Application no: **3/2022/0342**

Address: **Edencroft Kennels Hesketh Lane Chipping PR3 2TH**

Proposal: **Proposed change of use from kennels and cattery to single dwelling with garden.**

Proposed Plans & Elevations (1:50)

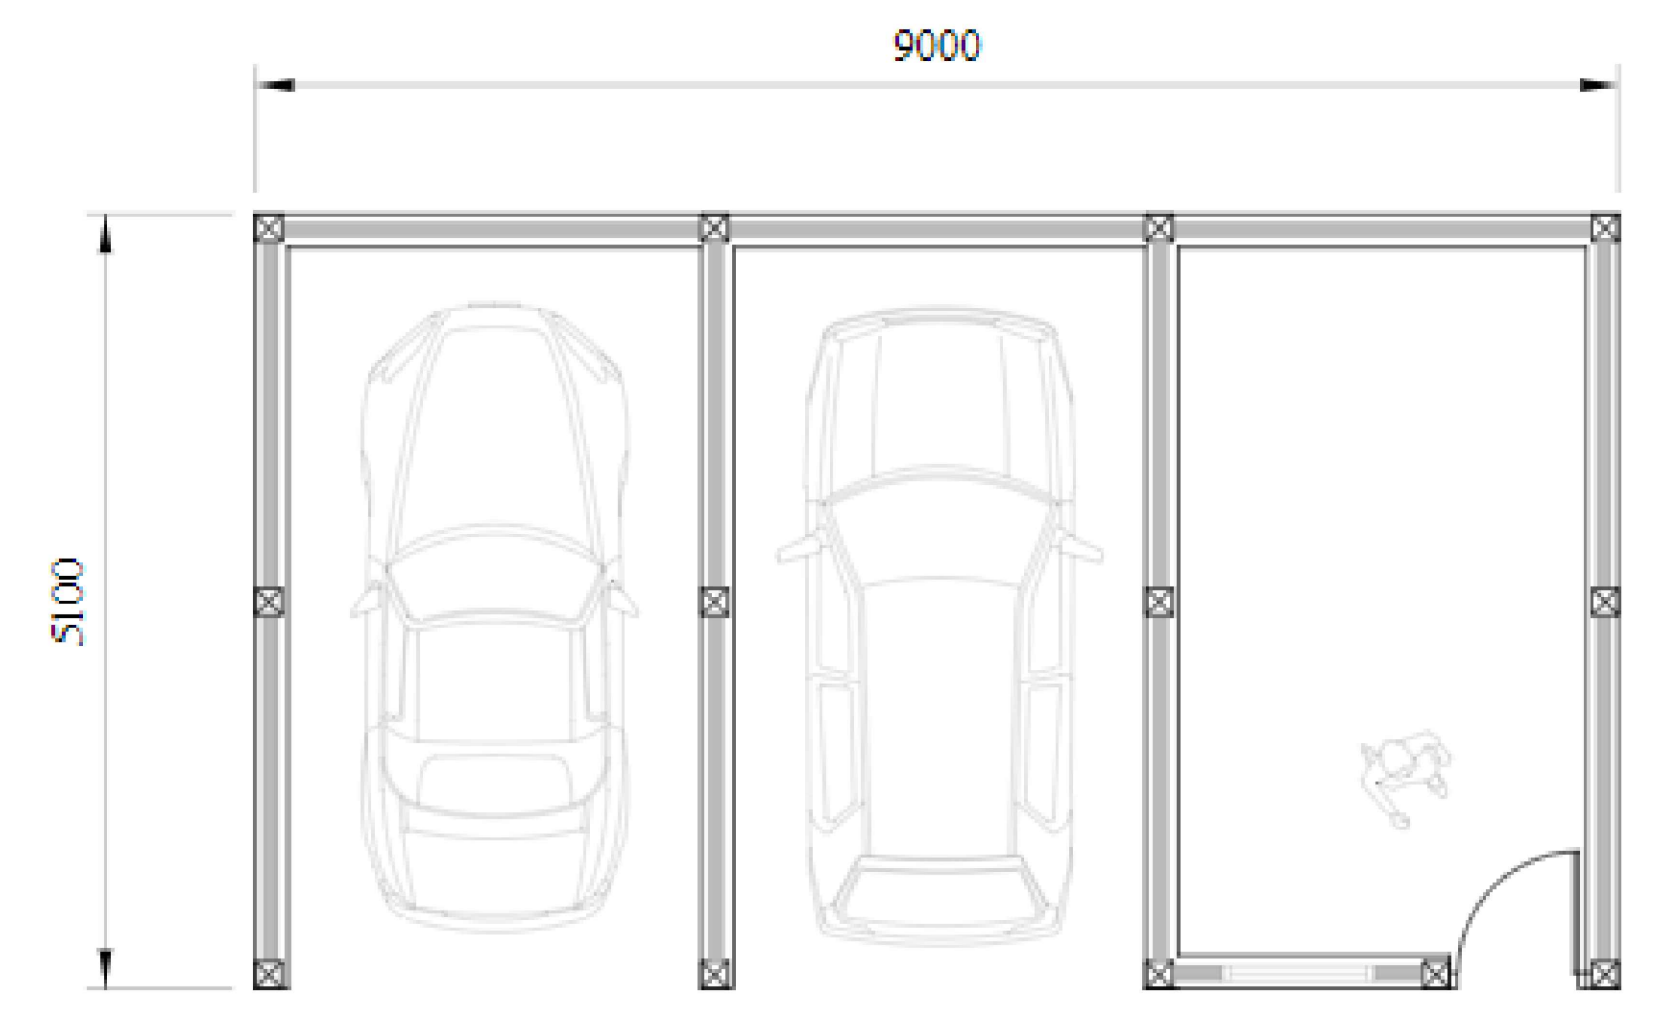
The LHA do advise the Agent/ Applicant that the proposed car port located on the driveway should be a minimum of 6m to comply with the LHAs guidance for a carport and also to fully cover the vehicle.
